**RE: Applications PR-2023-008710 & SI-2025-00082
U-Haul Site Plan
8200 Jefferson St NE, Albuquerque, NM**

Thank you for your time reviewing the U-Haul Site Plan application for the proposed development at 8200 Jefferson St NE. We received your comments dated February 11, 2025 and have addressed your comments. Below we have copied all your review comments and then provided written responses explain how each item was addressed.

NOTE: 4:1 POND SIDE SLOPES SHALL BE STABILIZED WITH 2" (MIN.) AGGREGATE MULCH AT 4" DEPTH OVER 3" DEPTH OF WOOD MULCH

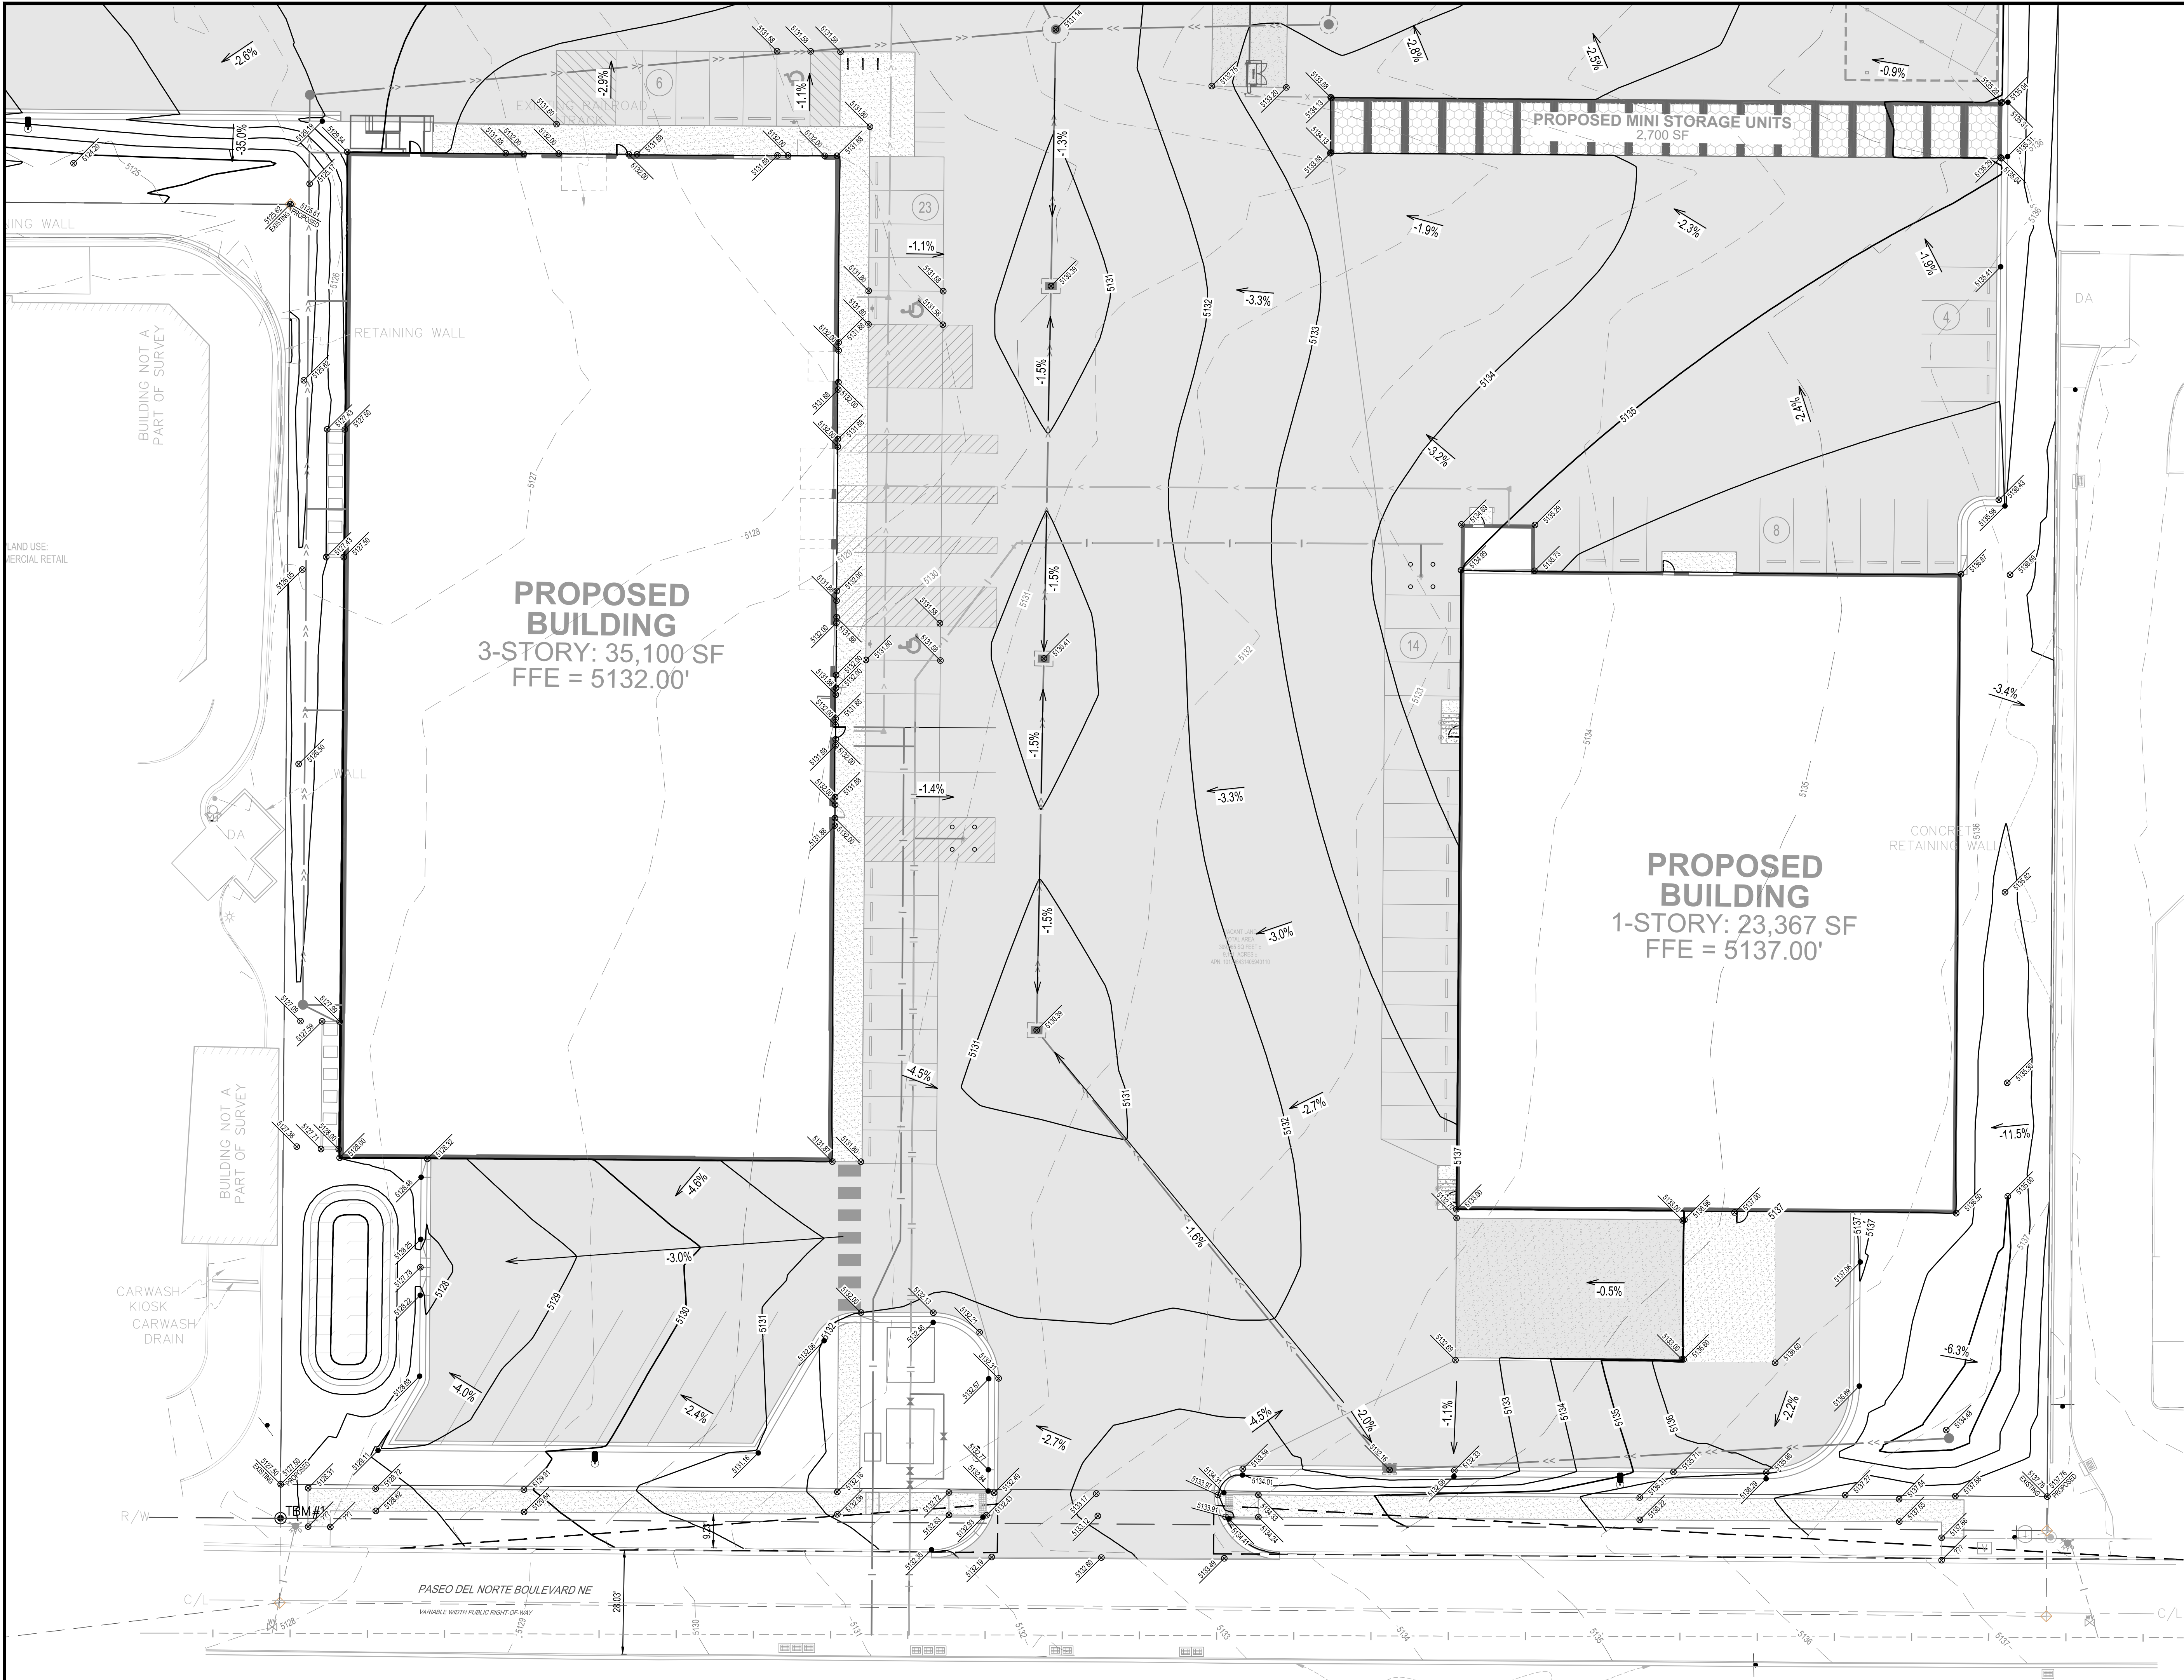
9. Clarify how any detention ponds would be stabilized. Any Drainage Ponds must meet Standard Specification 1013 or better. See Drainage Ponds Slope Stabilization and Seeding Requirements.pdf (cabq.gov)

ISG Response: This has been provided and follows Spec 1013.

DRAWN:	AE	
CHECKED:	PN	C5-10
DATE:	10/22/25

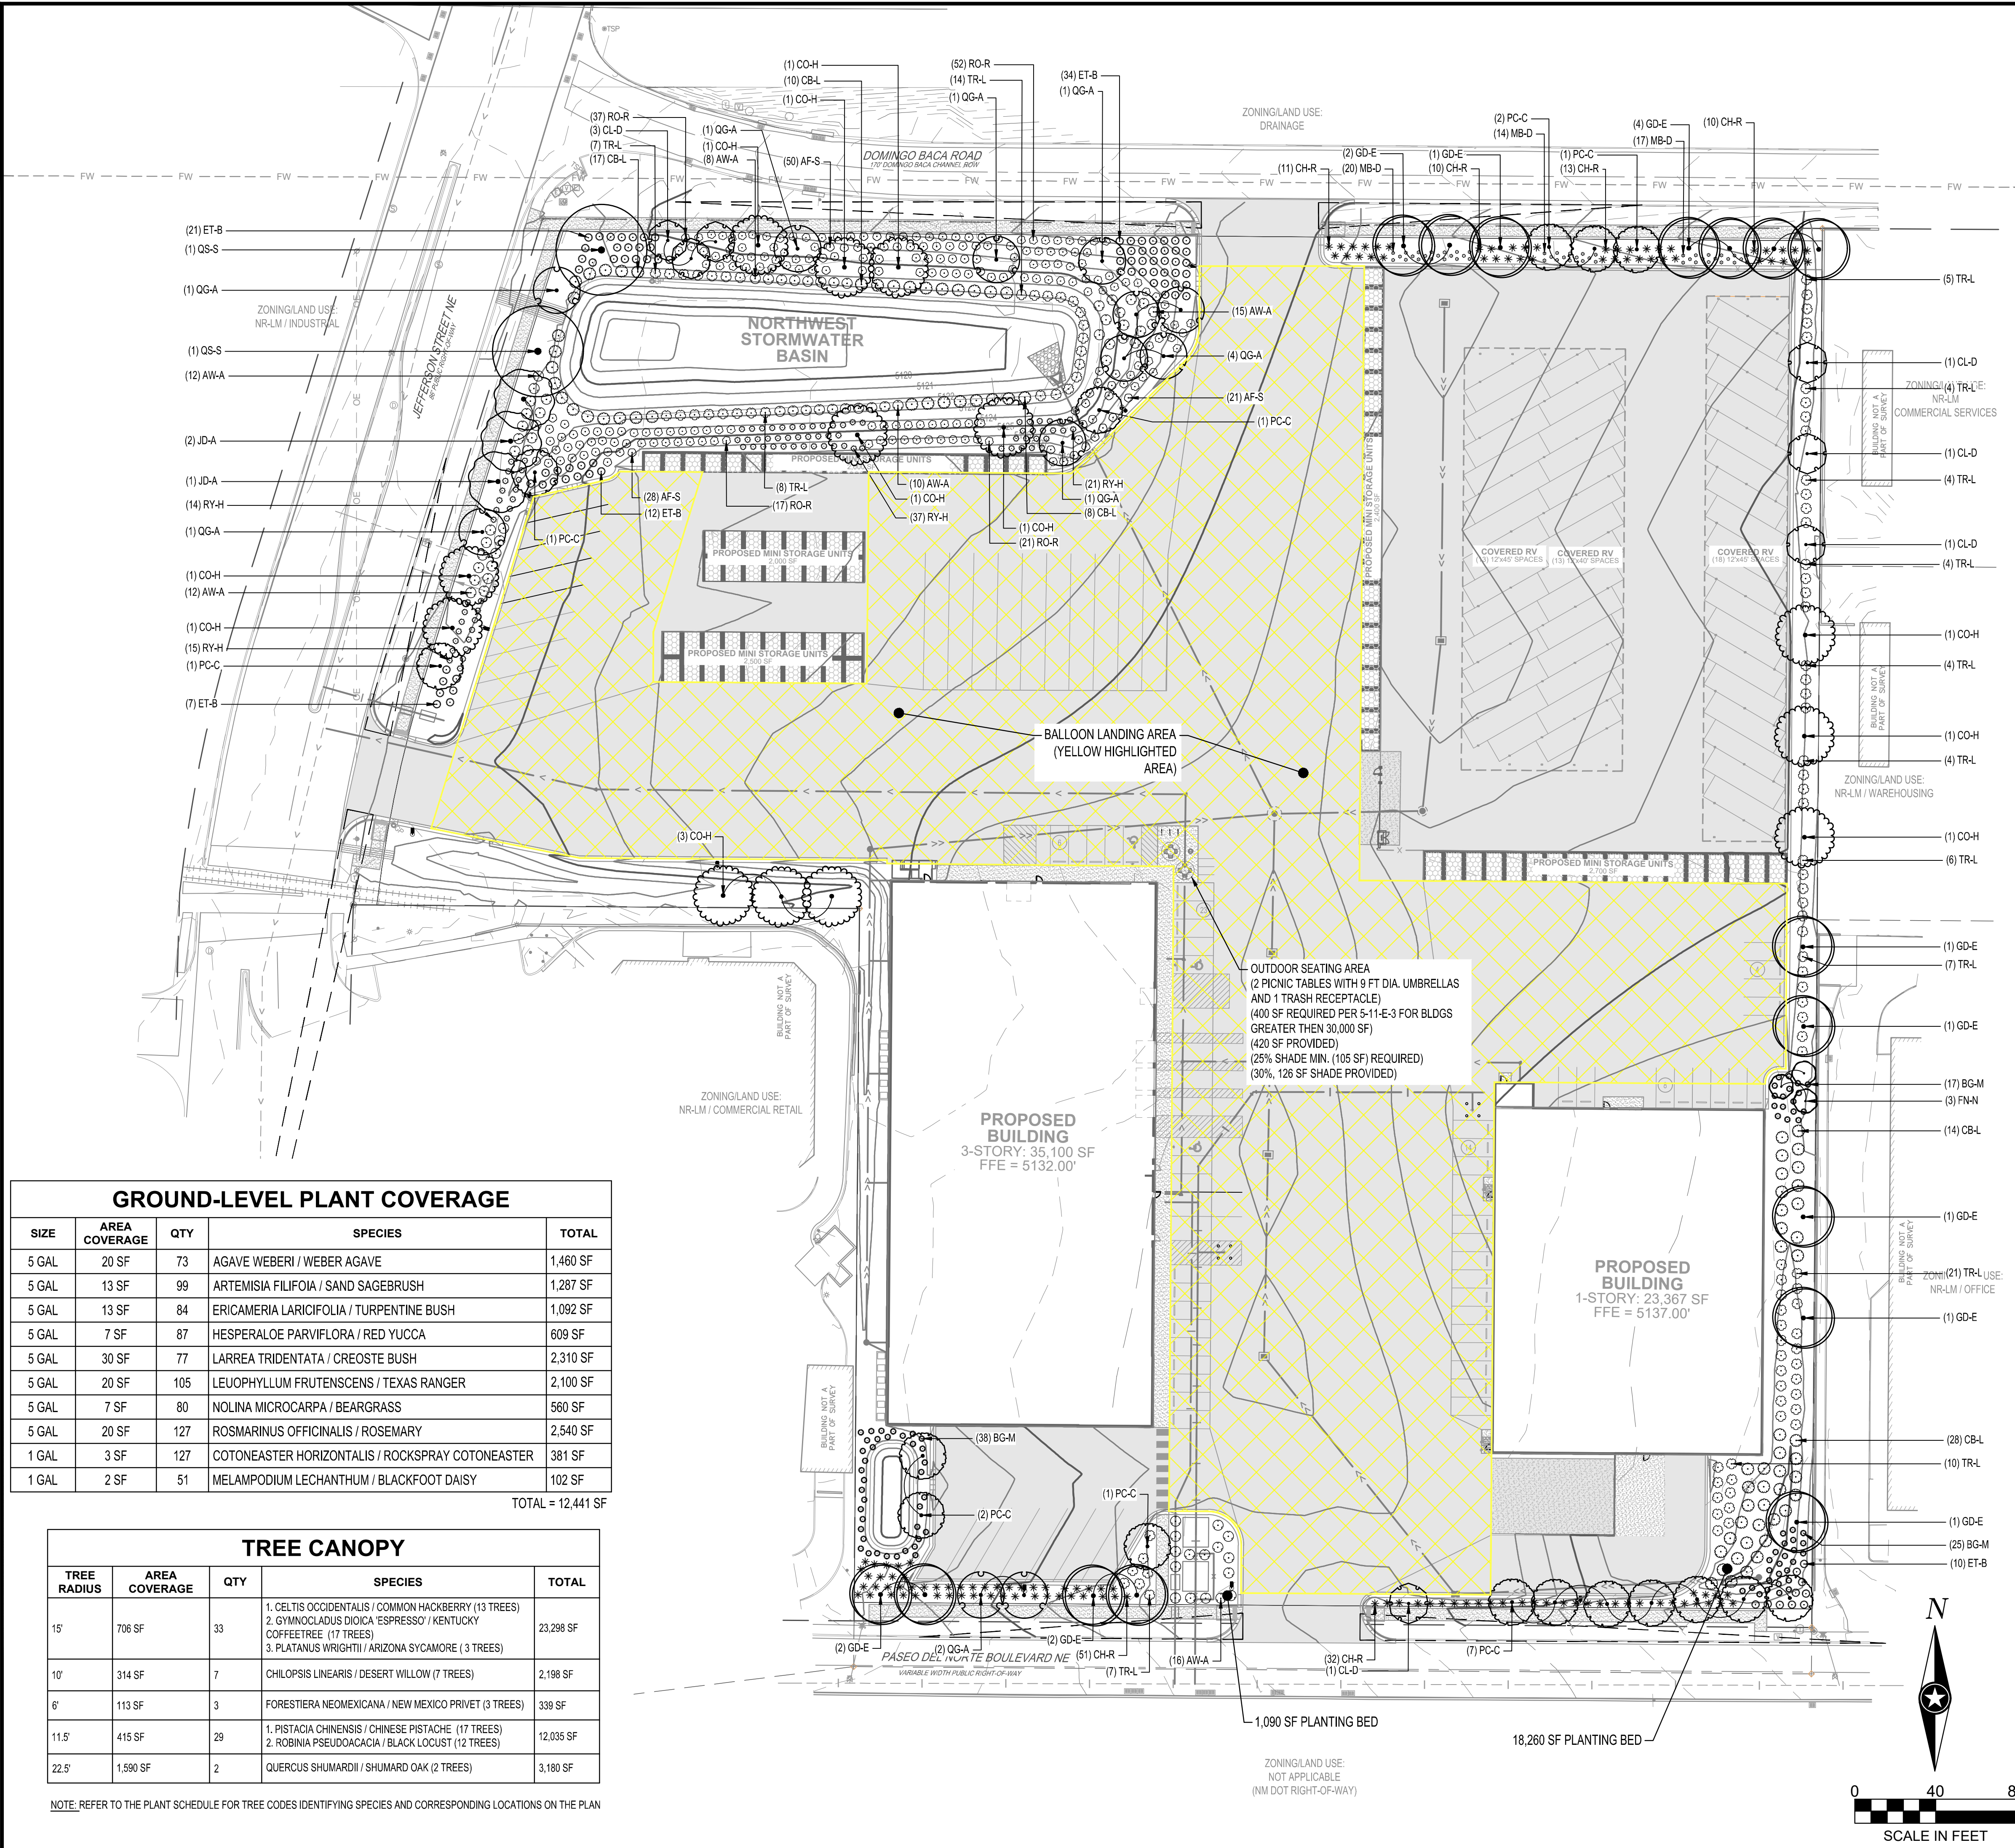
4. Street trees are required along Frontage Rd NE per IDO 5-6(D) STREET FRONTAGE LANDSCAPING. Confirm compliance.

5. Landscape design must meet requirement under IDO 5-6(F) PARKING LOT LANDSCAPING • Per IDO 5-6(C)(5)(c) The use of gravel or crusher fines as ground cover is limited to a maximum of 75 percent of any landscaped area, or 50 percent in DT-UC-MS areas. Calculations must be provided. Also, Per IDO 5-6(C)(5)(e) Organic mulch is required as ground cover under trees, within a 5-foot radius around the tree trunk, but not directly against the trunk. In these areas, weed barrier fabric is prohibited. (See exhibit in comment letter).

1. Alligator Juniper does not meet the intent for use as a street tree and is also not recommended for use as a street tree. Please replace with deciduous shade tree. Per IDO 5-6(C)(5)(e) Organic mulch is required as a ground cover under trees within a 5-foot radius around the tree trunk, but not directly against the tree trunk. In these areas, weed barrier fabric is prohibited. Please provide updated tree planting details. Parking lot trees are required per IDO 5-6(F)(2)(c). Show parking lot trees as required by IDO.

ISG Response: This has been updated.

ISG Response: Calculations have been provided.

ISG Response: This has been updated.

DRAWN:	GBV	
CHECKED:	ARA	C6-10
DATE:	10/22/2025

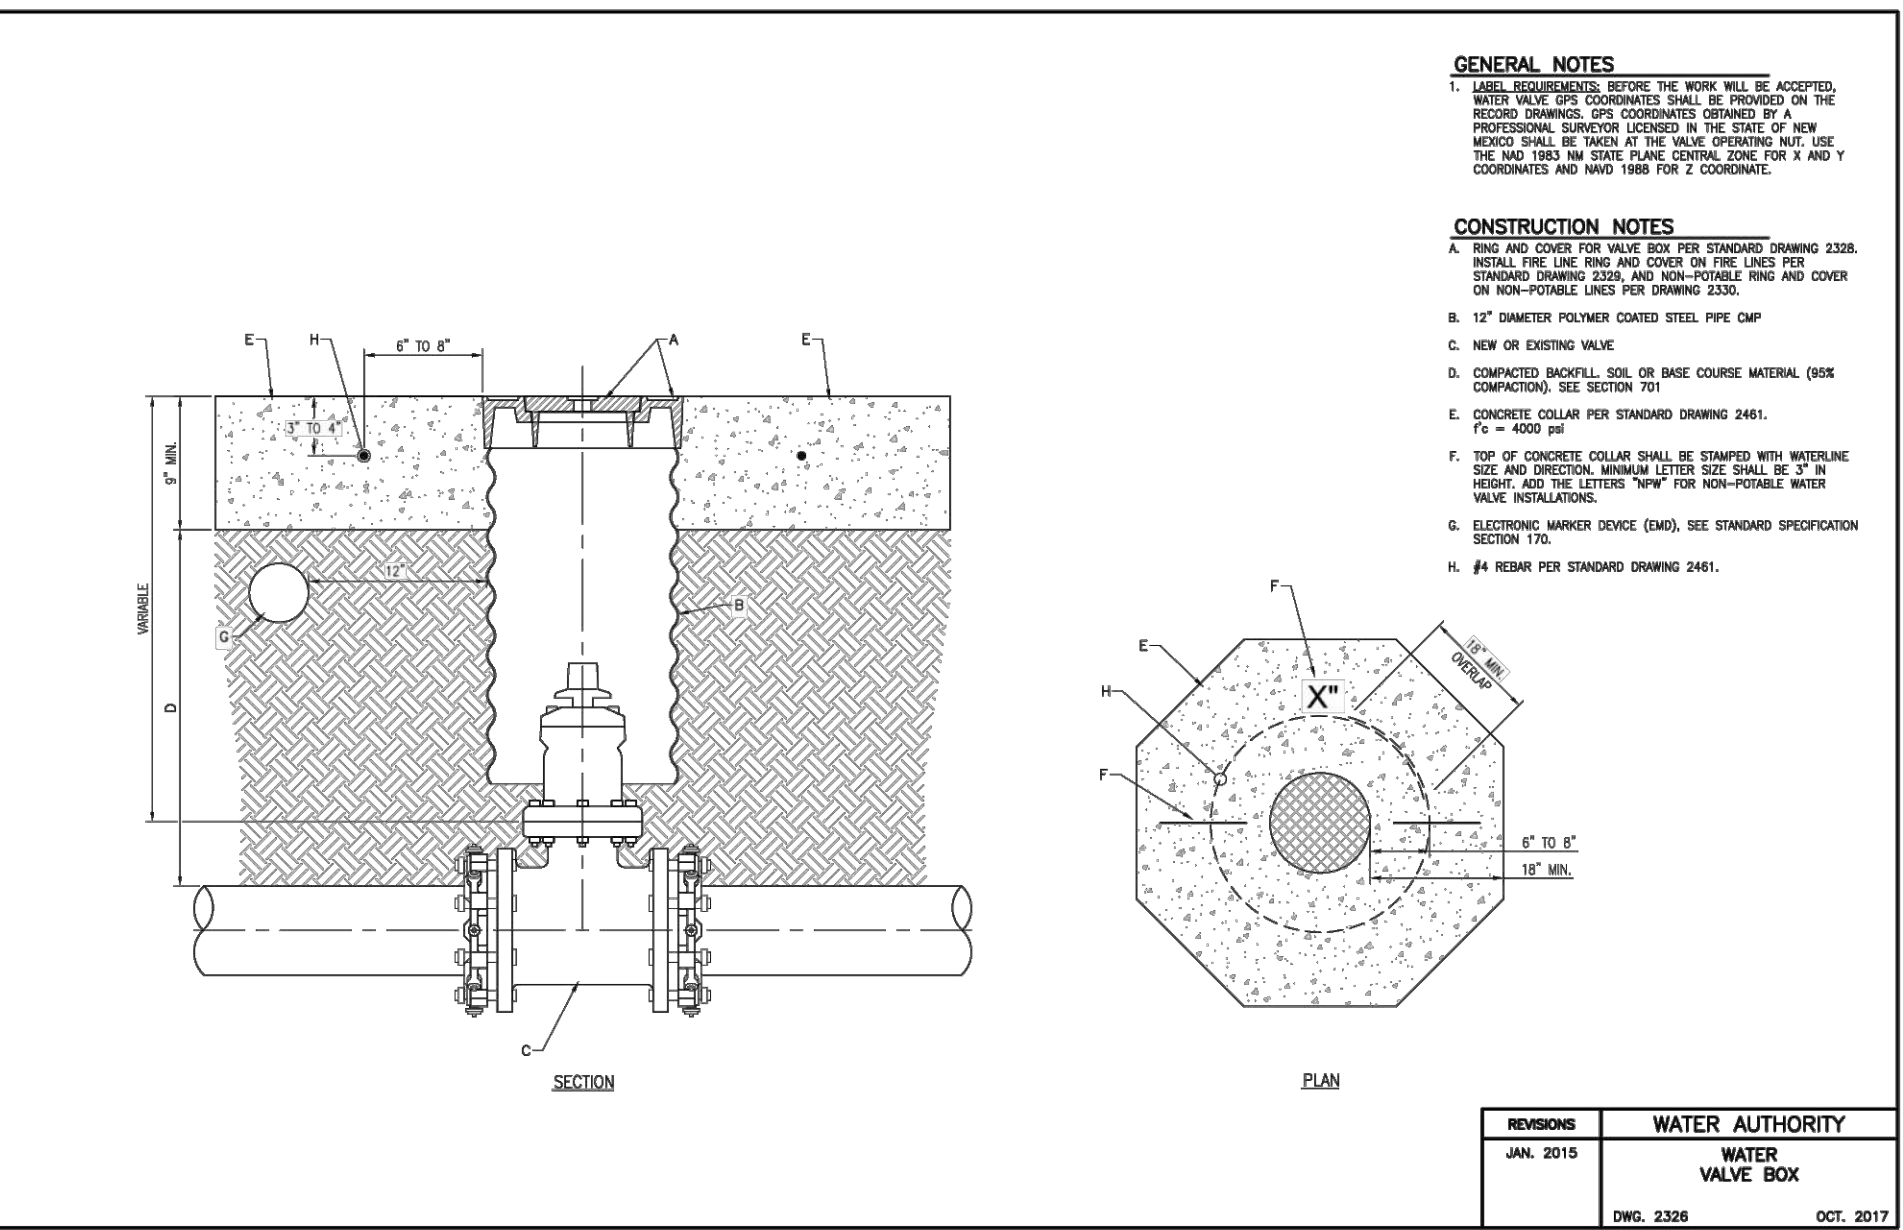
7. Provide a dimensioned lighting plan that demonstrates how it meets IDO section 3-4-K and 5-8.

ISG Response: This has been provided on Sheet C6-10 Site Photometric Plan and complies with all IDO standards.
